Charlotte Department of Transportation

Memorandum

Subject: Rezoning Petition 08-130: Located on the northwest corner of North Davidson Street and Charles Avenue
(revised 9/9/08)

PROPOSED SITE PLAN  
SCALE: 1/16" = 1'-0"

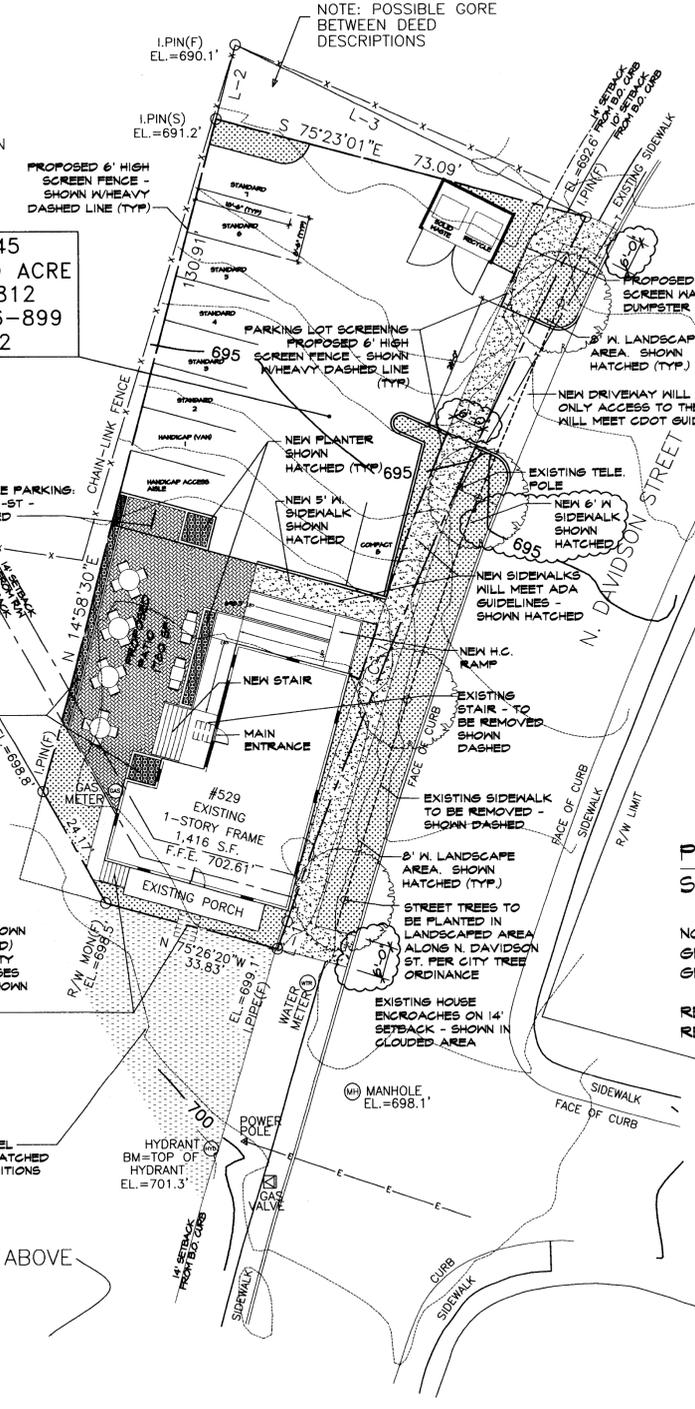
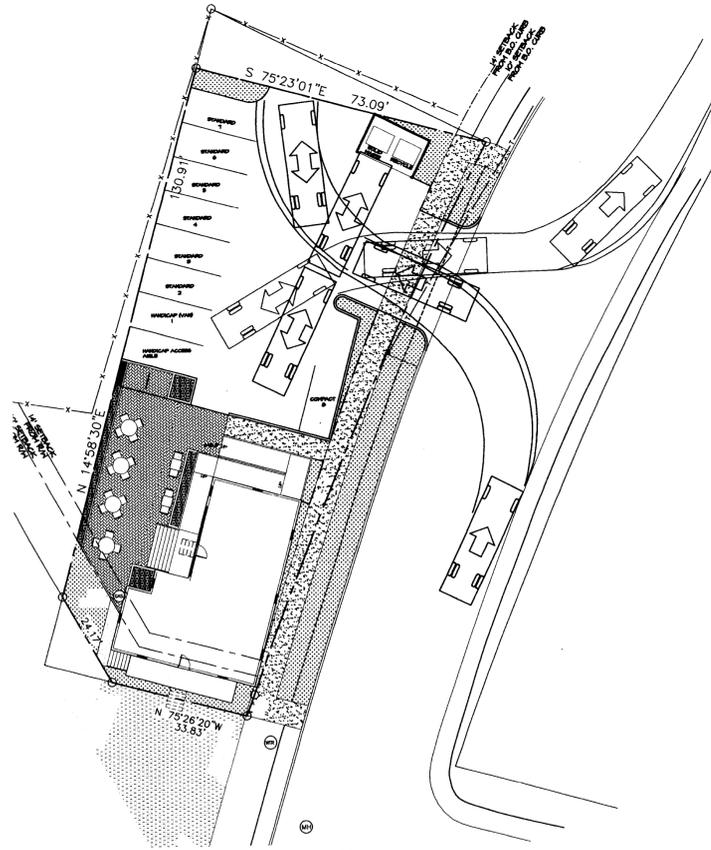
1. Two of the three optional requests proposed on the site plan will not be supported by CDOT. The first request is not supported because the street trees need to be located between the curb and sidewalk as shown on the plan. The second request is not supported because the site is constrained and at a critical point in a curve where sight distance is an issue, so paved parking provides the optimal maneuvering surface. These notes should be removed from the site plan. (*Previous review comment*)
2. The note on the site plan regarding the waste collection procedure is not sufficient and needs to be revised to specify that a front-loading waste collection vehicle must service this site.
